Further objection

Application No: EP/57/20/HH
Site Address: 32 Vermont Drive East Preston West Sussex BN16 1LA
Description of works: Loft conversion with side dormer and hip to gable extension to rear.

PROPOSED FIRST FLOOR PROPOSED 1ST FLOOR PLAN + SECTION

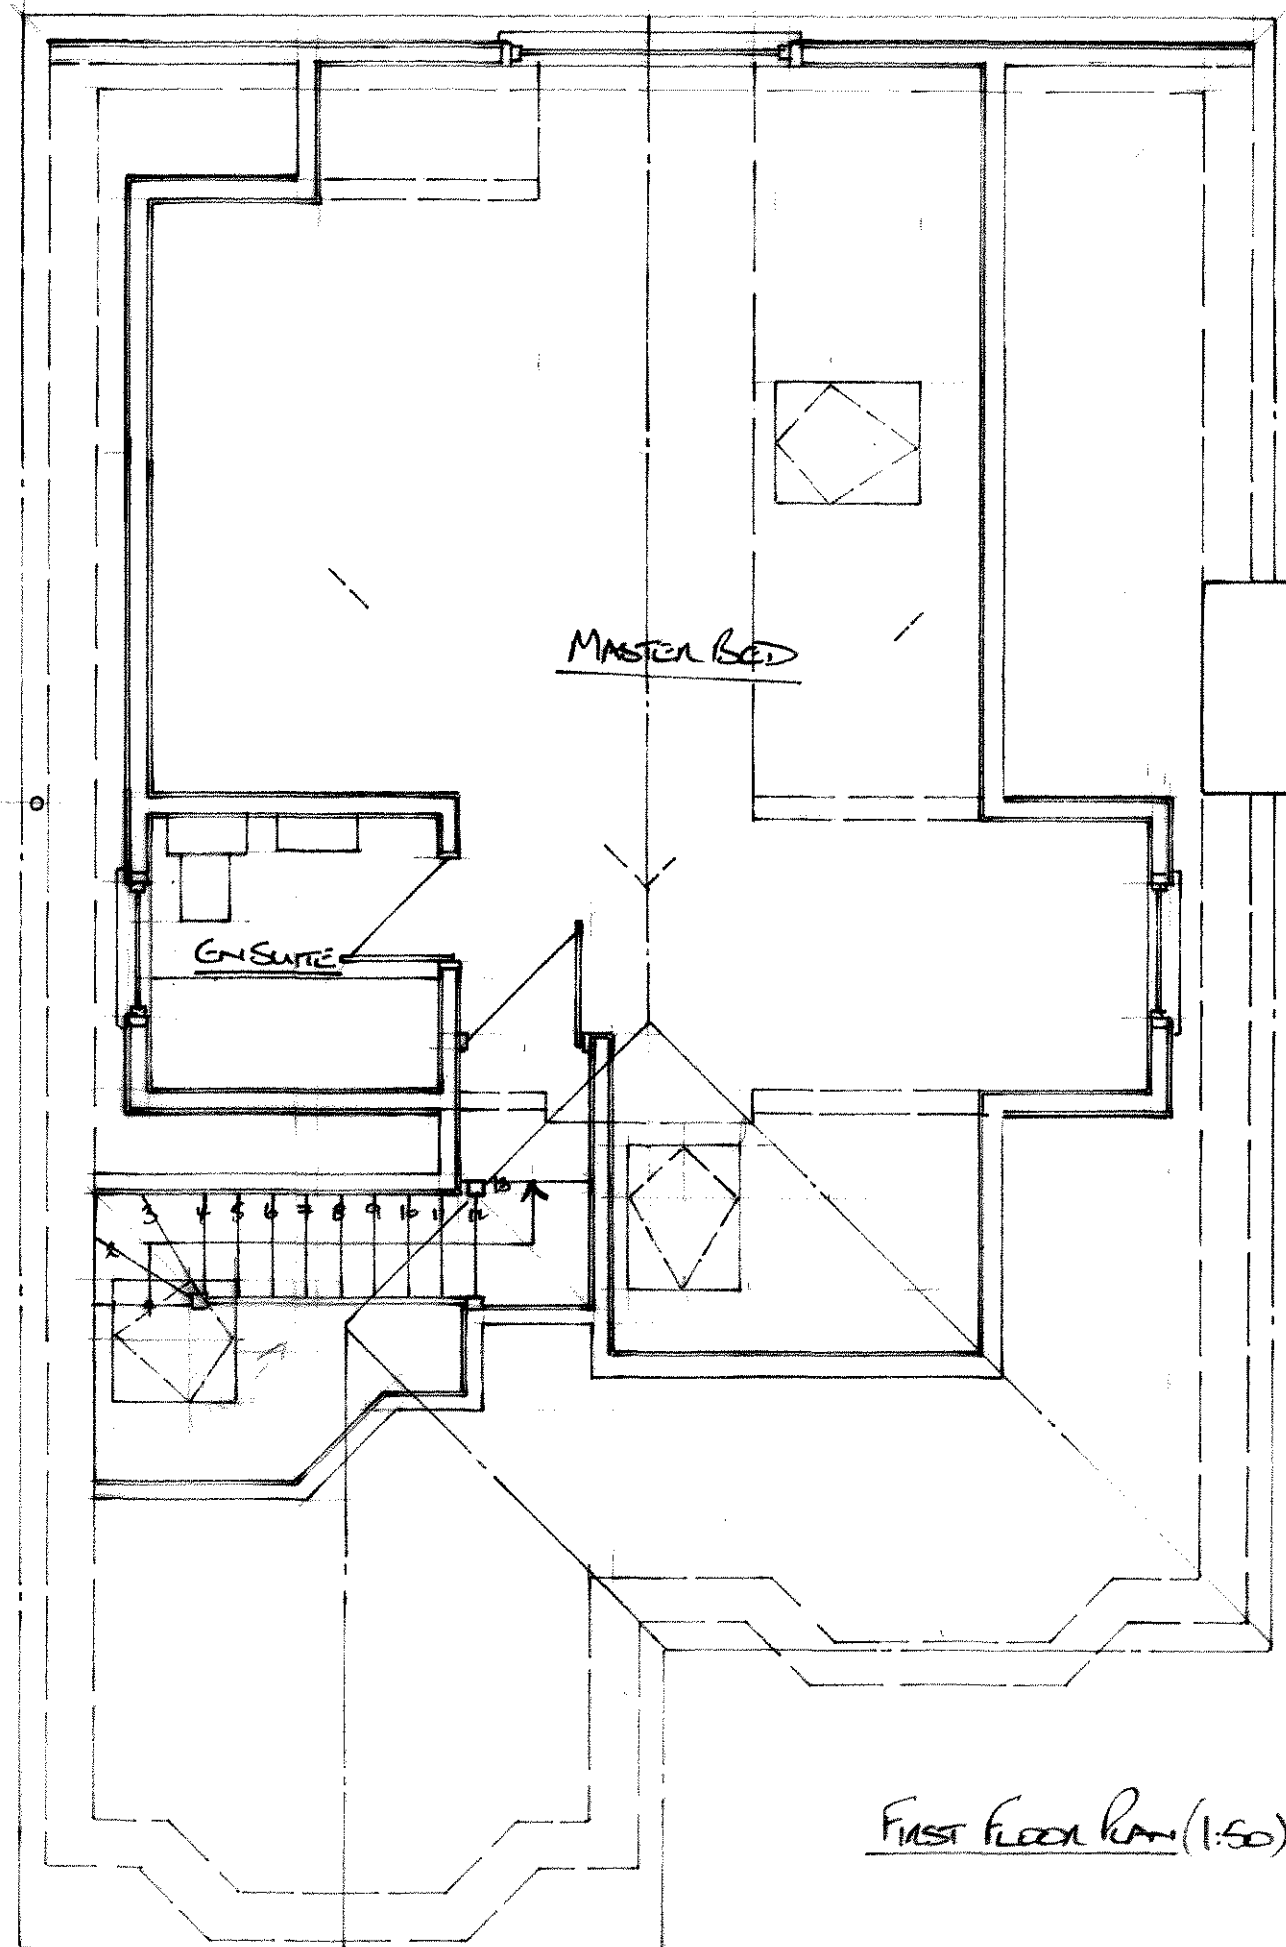
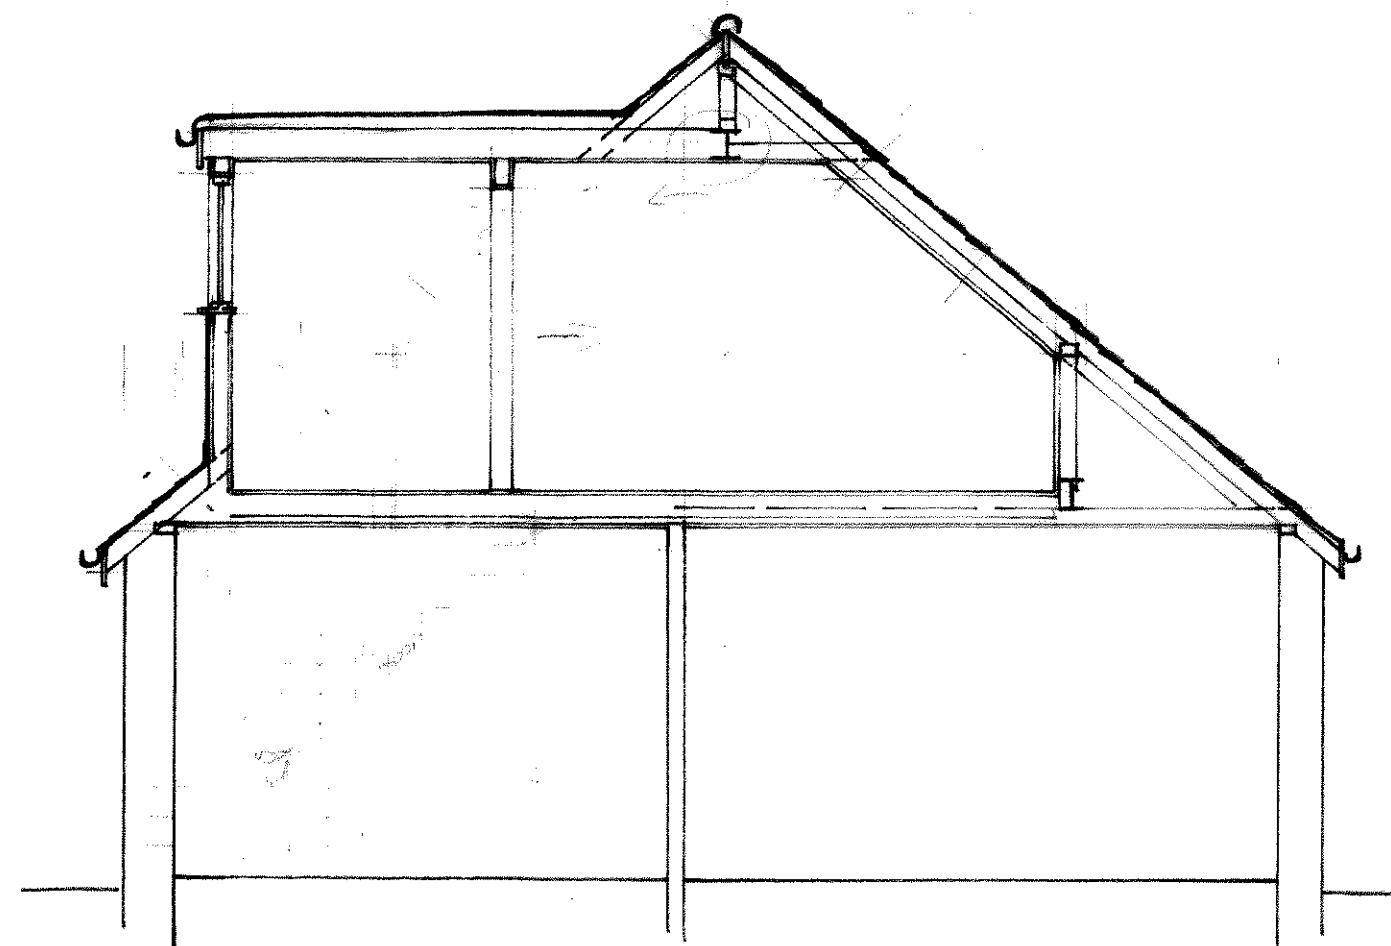
Thank you for your response but on further investigation the two windows on the west elevation on the ground floor have been bricked up and I cannot see anything in the application about replacing them. I assume the window on the west elevation 1st floor will be of obscured glazing. I am also concerned that the first floor rear dormer window will be too near the boundary and be intrusive to the neighbouring properties.

Existing side (west) elevation (1:100)

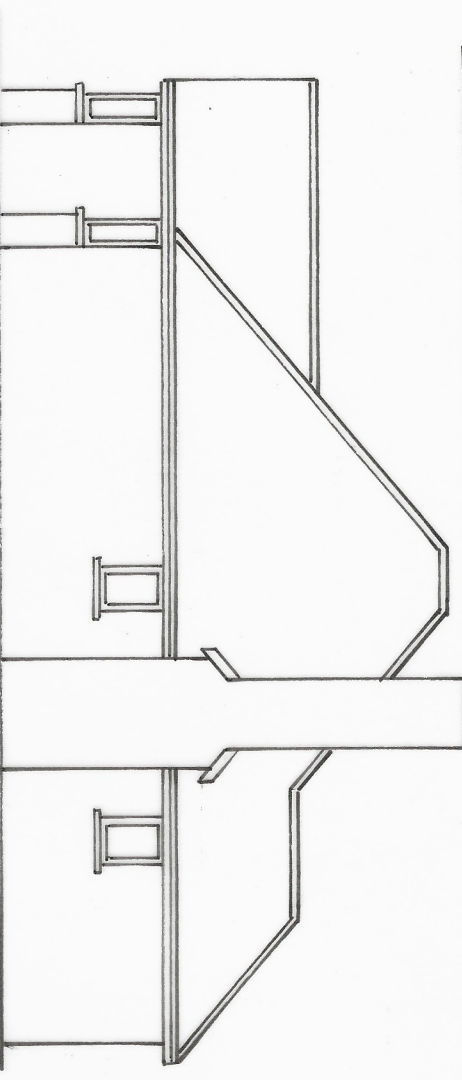
before I can decide about this application there seem to be a few questions about the drawings. I cannot relate the existing elevation plans to the property as it currently shows windows which are not there. The application form is impossible to read in the way it has been uploaded so it is not clear what materials and glazing would be used. The location plan is confusing as it uses a very out of date plan and does not reflect the current properties in the nookery.
